BARANGAROO SOUTH
C1 BUILDING - BASEMENT EXIT INTERSECTION WORKS

This letter has been prepared in response to a Road Safety Audit (RSA) report prepared for proposed intersection modifications at the basement exit at Hickson Road, Sussex Street and Napoleon Street, Barangaroo.

Table 1-1 Possible Risk Mitigation Measures in response to Road Safety Audit (DC Traffic Engineering, March 2018)

TCS No 4625

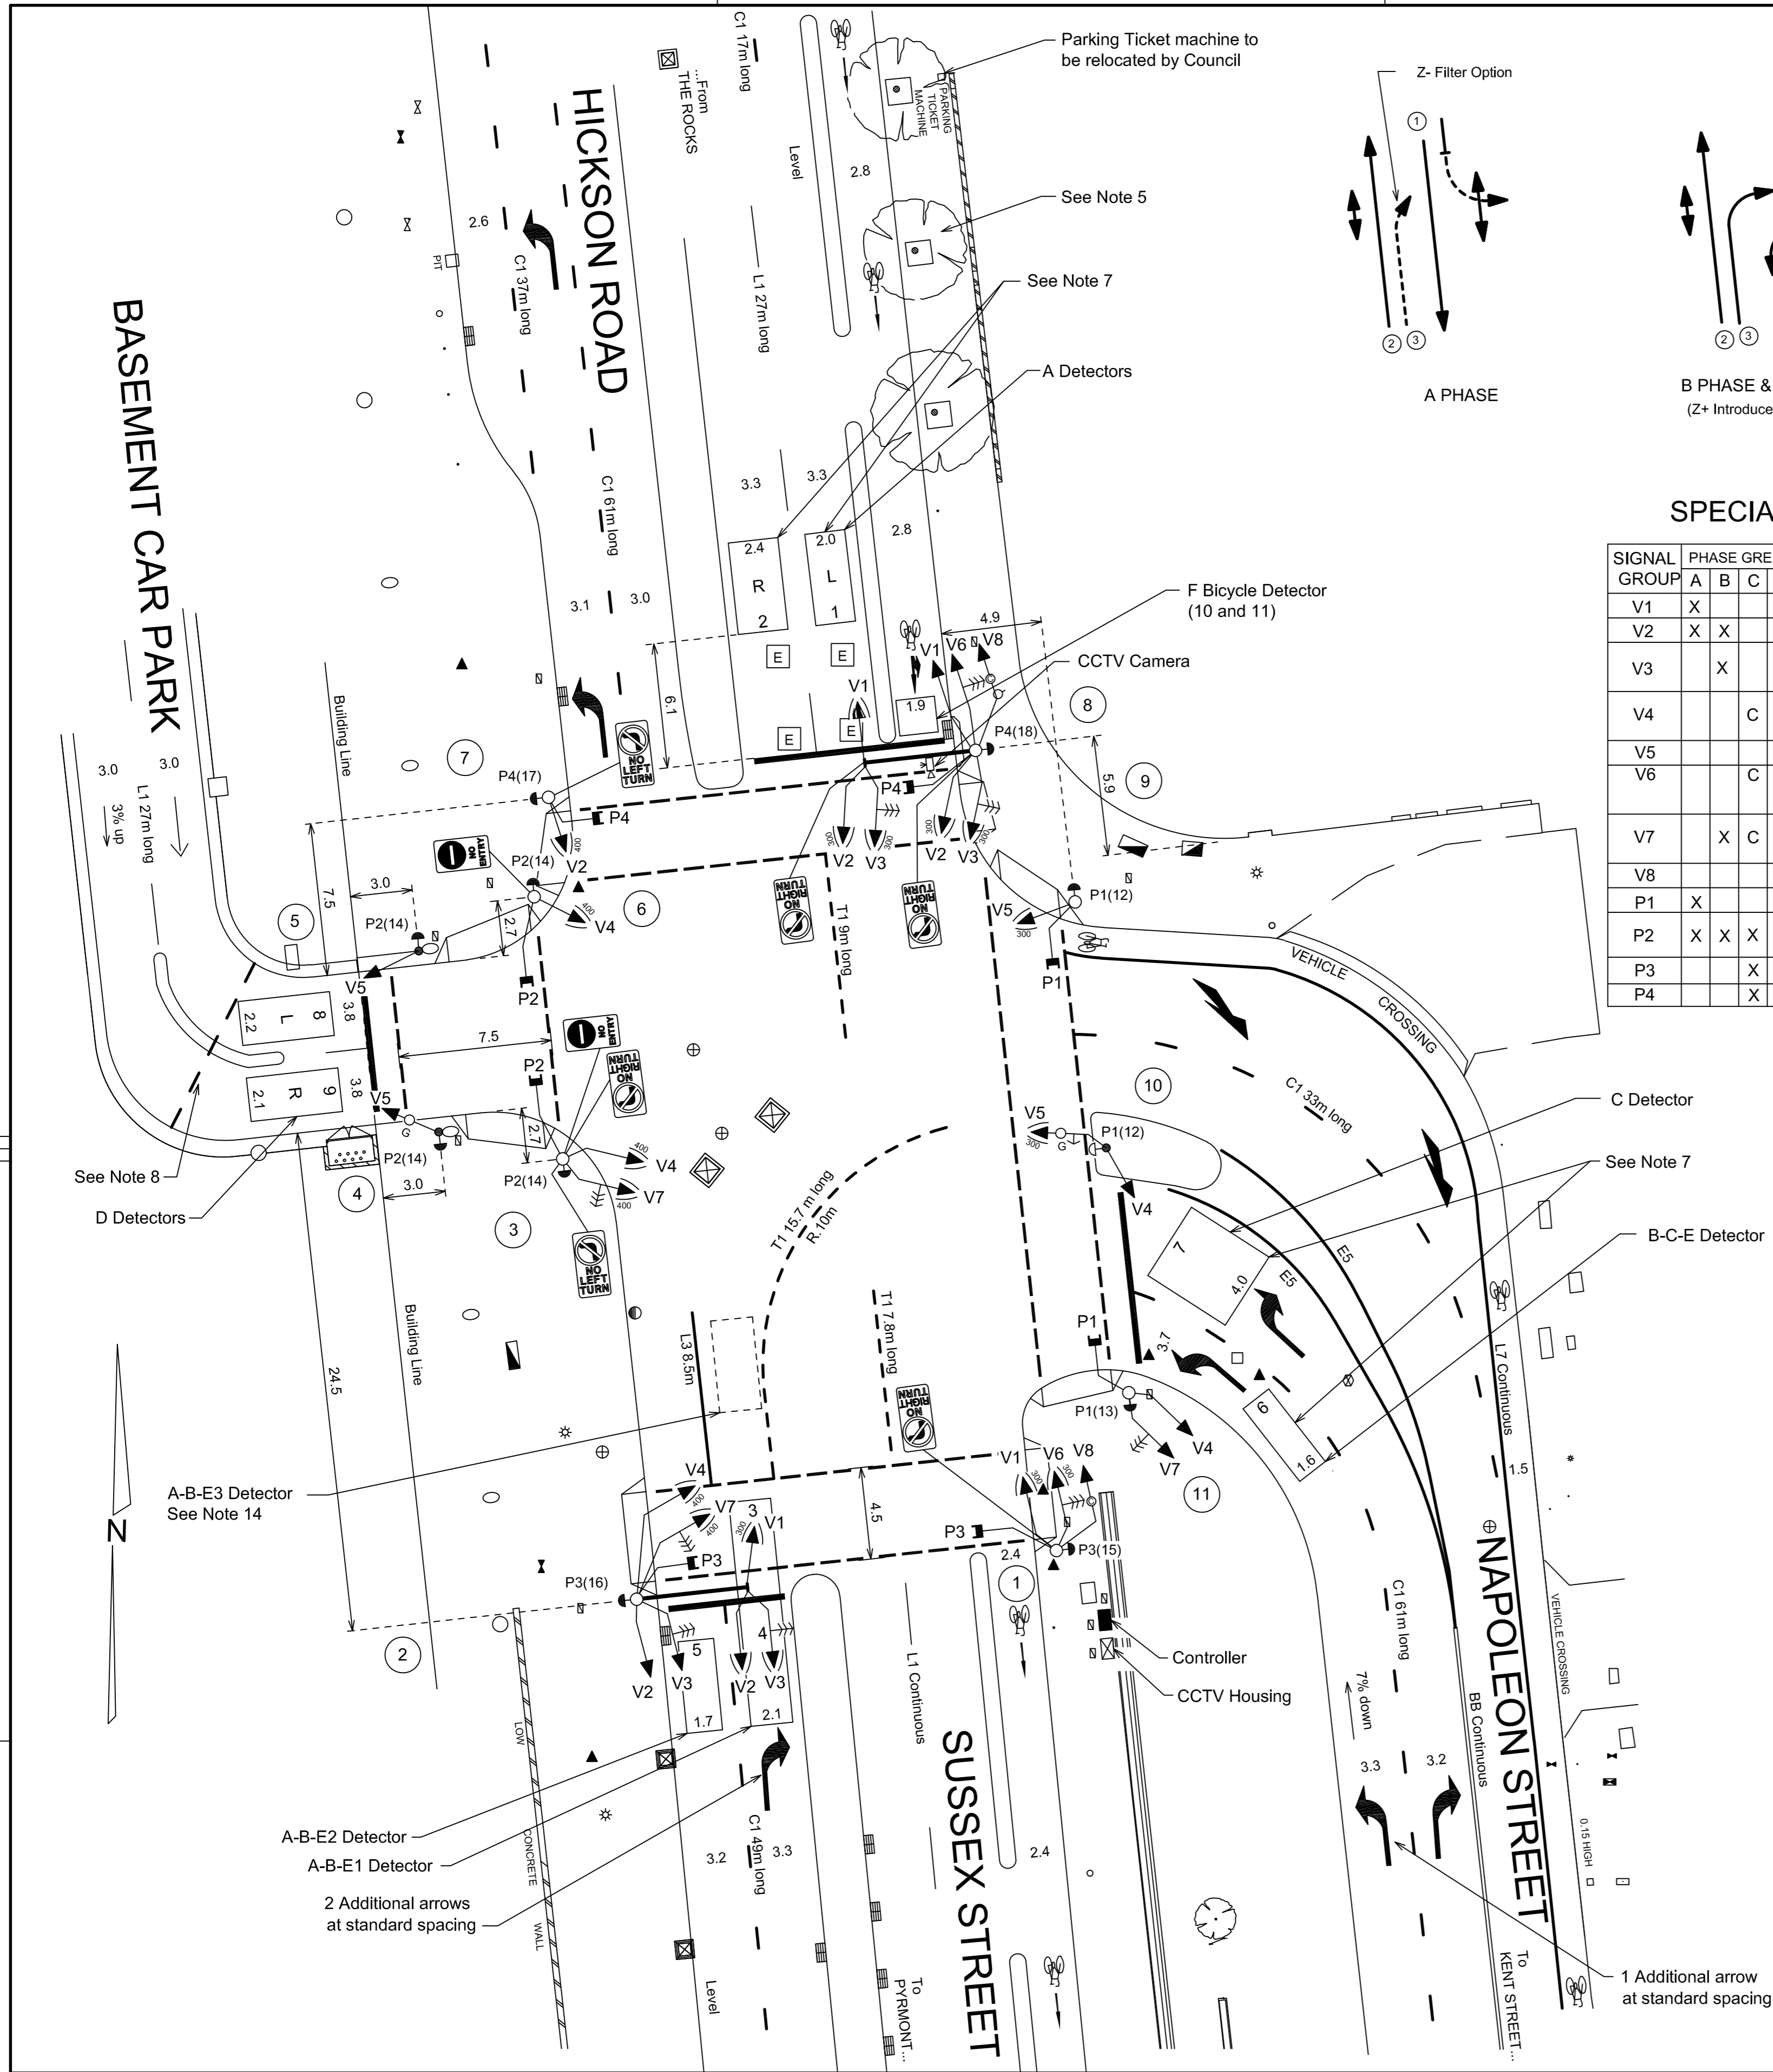
Audit Reference	Description	Possible Risk Mitigation Measures (refer to footnotes below)
C-1	Position of hold line in the basement car park approach to the intersection	A
C-2	Interface between basement car park ramp and proposed pedestrian crossing	B, C and D
C-3	Impact of relocated pedestrian crossing on the operation of the intersection	A
C-4	Western footpath of Hickson Rd / Sussex St	E
C-5	Impact of colonnade on pedestrian "see-through" perceptions	B and C
C-6	Basement car park ramp in approach to signalised intersection	No specific measures required, as the roller door remains open all day while the basement car park is in operation.
1	Impact of colonnade support pylons on driver visibility to pedestrians	B, C and D
2	Signal Posts	This has been addressed in the revised Traffic Signal Plan dated 19 th March 2018.
3	TCS Plan post numbering	This has been addressed in the revised Traffic Signal Plan dated 19 th March 2018.

4	C phase on TCS Plan – conflict between left turn movement for cyclists and pedestrian crossing	F
5	Signal Posts	This has been addressed in the revised Traffic Signal Plan dated 19 th March 2018.
6	Egress driveway from building car park	G
7	Primary and dual primary signals in building car park egress lane	H
8	Use of signals and signs	To be considered further during detailed design
9	Pavement loop detectors	To be considered further during detailed design, in light of existing and proposed utility services that may conflict with the location of the loop detectors.

- A. Placement of a dynamic flashing light on the wall adjacent to one or both of the basement exit lanes, which is linked to the red signal at the intersection, refer to **Figure 1-2**.

- B. Provision of signage at the eastern end of the concrete median within the basement car park, warning vehicles exiting of the impending pedestrian crossing. An example of such signage is presented in **Figure 1-3**.

- C. Provision of warning signage on the proposed colonnade columns to alert pedestrians to vehicles exiting the basement car park. Examples of such signage are presented in **Figure 1-4**.

- D. Provision of in-ground pedestrian lights (red, linked to the pedestrian traffic signal lights) between the C1 ground floor building / façade line and the line of colonnade columns. It is noted there are currently trials in place of these lights at two locations in the Sydney CBD (Goulburn St / Pitt St and Hay St / Dixon St).

- E. Extend proposed kerb ramps to cover full width of the proposed pedestrian crossing (7.5 metres), which will cover portions of the footpath under the colonnade (within Barangaroo South) and beyond the colonnade (on the footpath within the Sussex Street / Hickson Road reserve).

- F. Consider restricting the left turn movement for cyclists from Hickson Road to Napoleon Street to avoid conflict with pedestrian movements on the northern side of the intersection (C phase movements).

- G. Consider line marking and signage on the approach to the two exit ramps in the basement car park to inform drivers that left lane only turns left onto Hickson Road and right lane only turns right onto Sussex Street.

- H. Consider various options for the placement of primary and dual primary signal lanterns at the intersection. It is noted the current design plan shows the lanterns on signal posts adjacent to the proposed colonnade columns (not directly on the support pylons as noted on page 15 of the RSA). Alternative options that are worthy of further consideration as part of the detailed design process include:

- a. Placement of signal lanterns directly on the colonnade columns (with or without outreach arms, depending on visibility and clearance requirements for vehicles exiting the basement).

- b. Placement of signal lanterns on outreach arms directly attached to the face of the building.
